WEST SUSSEX COUNTY COUNCIL CONSULTATION

TO:	Arun District Council
FROM:	Highways, WSCC
DATE:	10 September 2018
LOCATION:	Tesco Express, 126, Felpham Way, Bognor Regis, PO22 8QW
SUBJECT:	FP/186/18/DOC Approval of details reserved by condition imposed under FP/161/17/PL relating to condition 2-Delivery Management Plan.
DATE OF SITE VISIT:	
RECOMMENDATION:	☐ Advice ☐ Objection ☒ Modification ☒ No Objection ☐ More Information ☐ Refusal
S106 CONTRIBUTION TOTAL:	£ See below for breakdown.

Title: Site Location Plan indicating
location of 'Delivery Area'

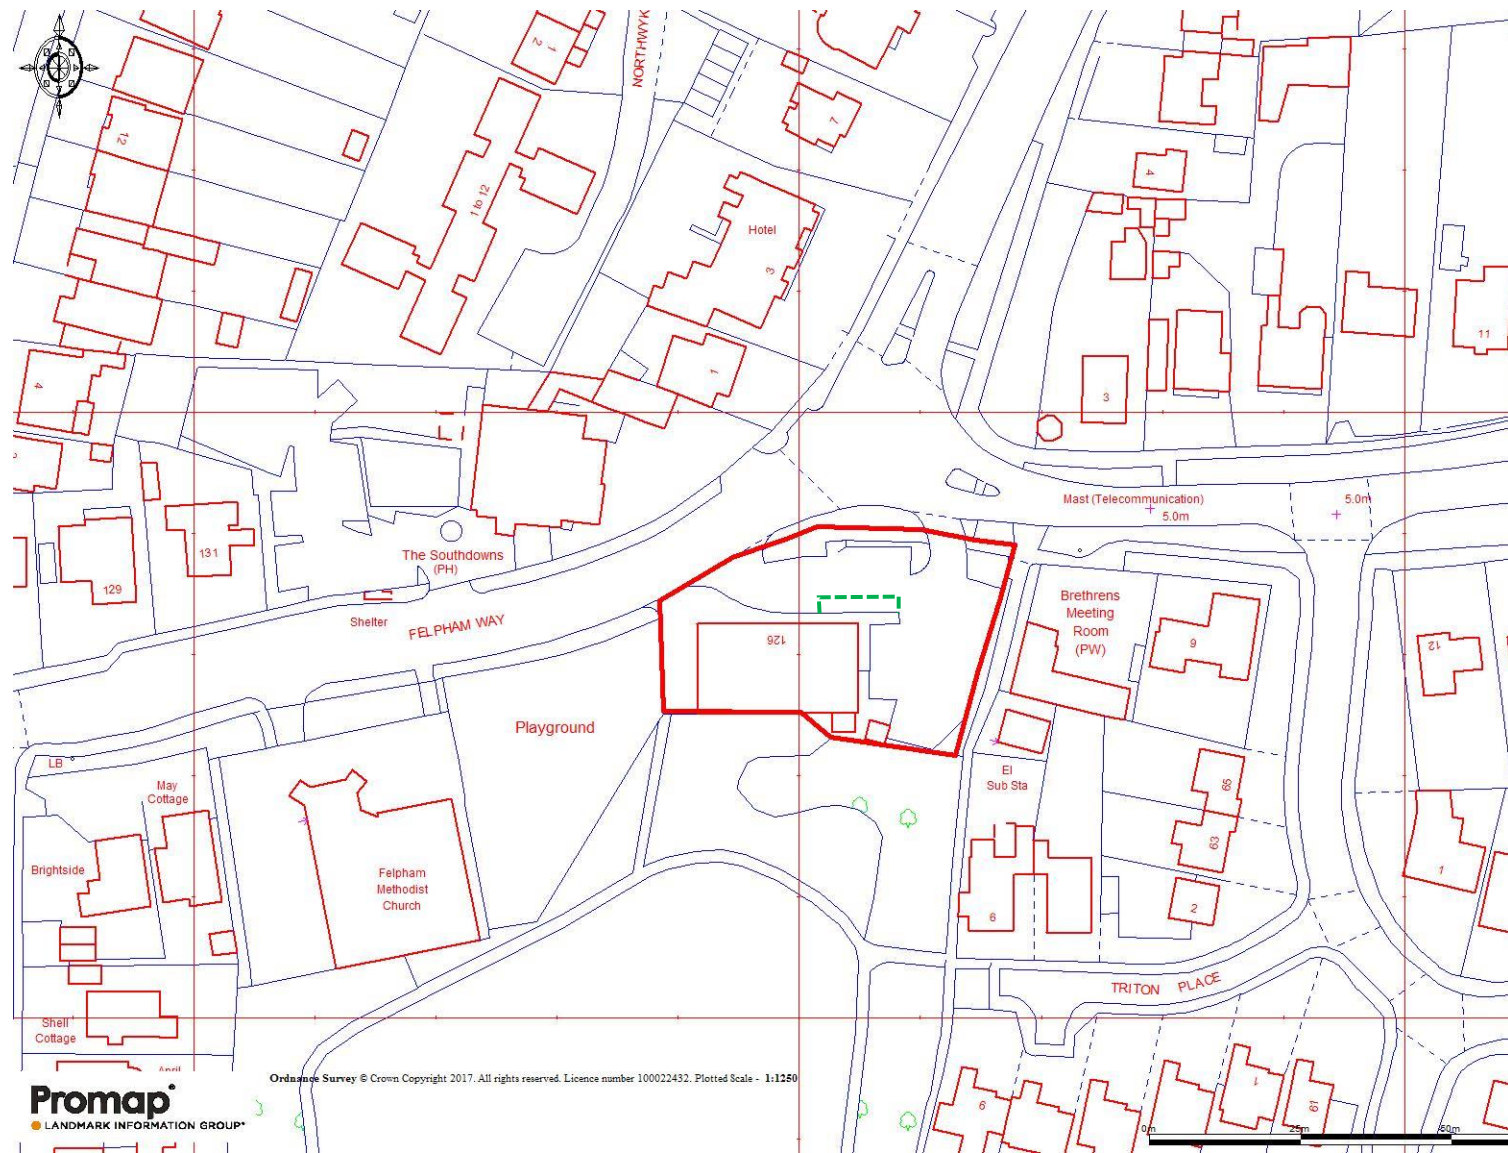
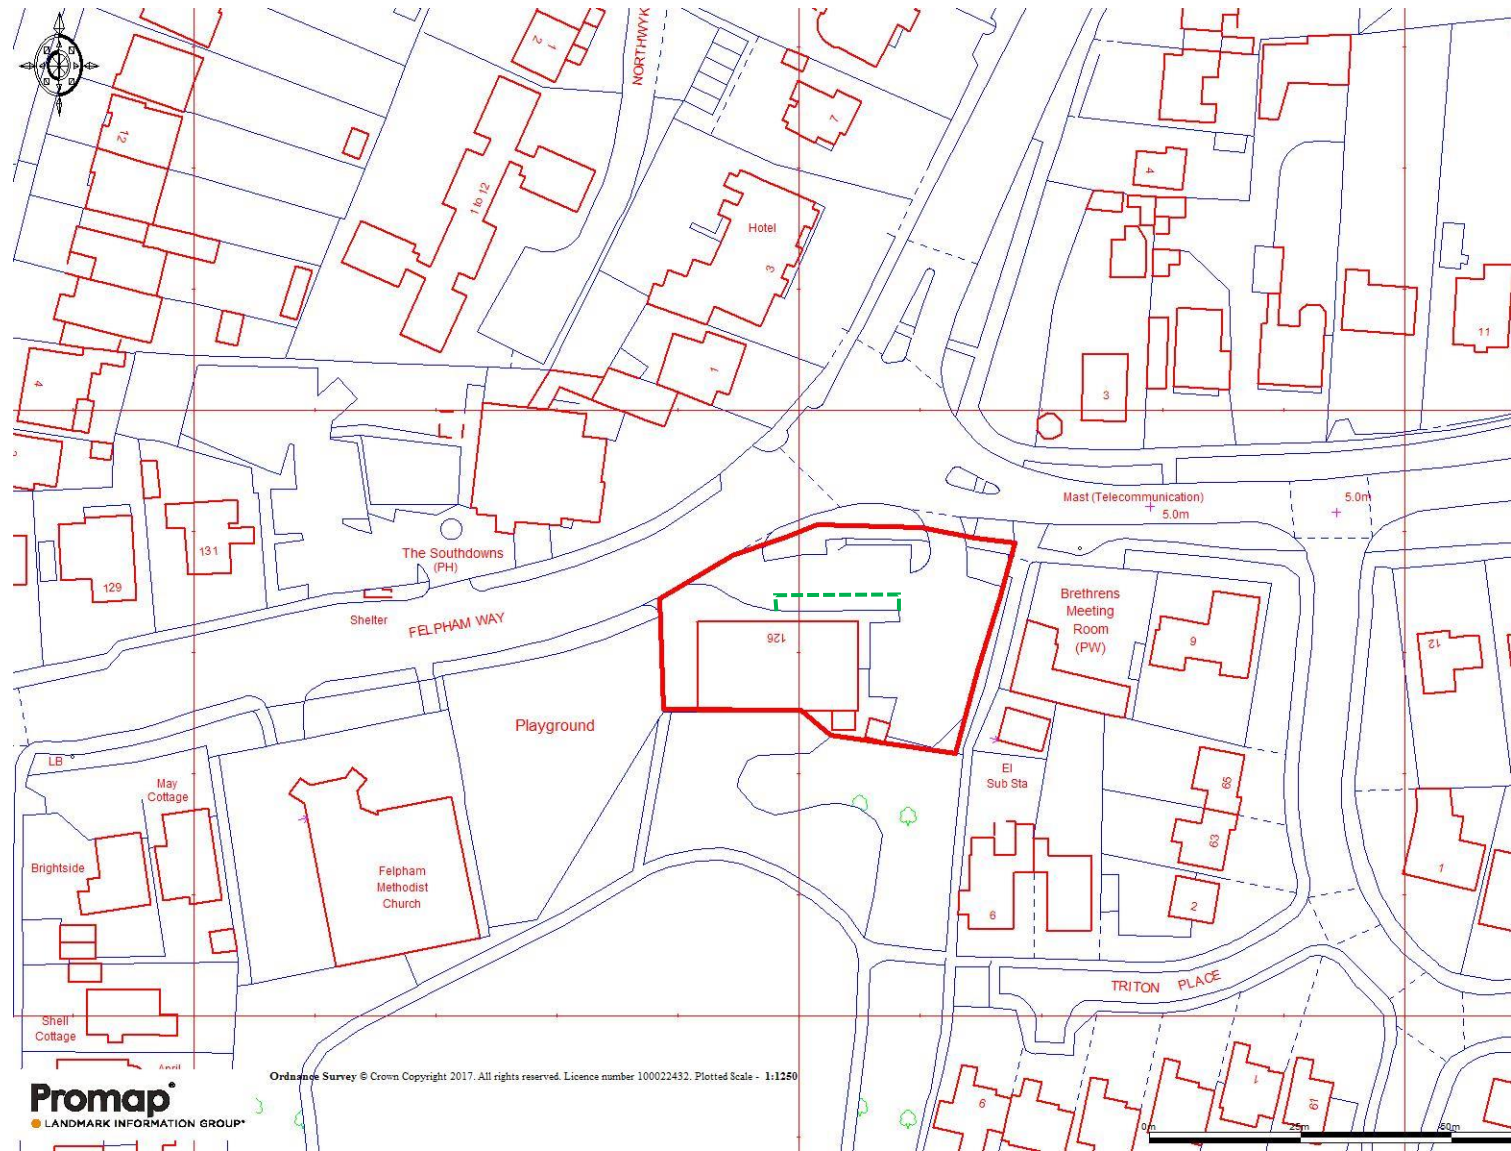
The area shown on the plan in green dashes appears to be the size of a stationary vehicle only. The area should be extended to the west to ensure there is room for large vehicles to manoeuvre into the space from the site access and ensure vehicles do not park adjacent to the shop entrance and block the access.
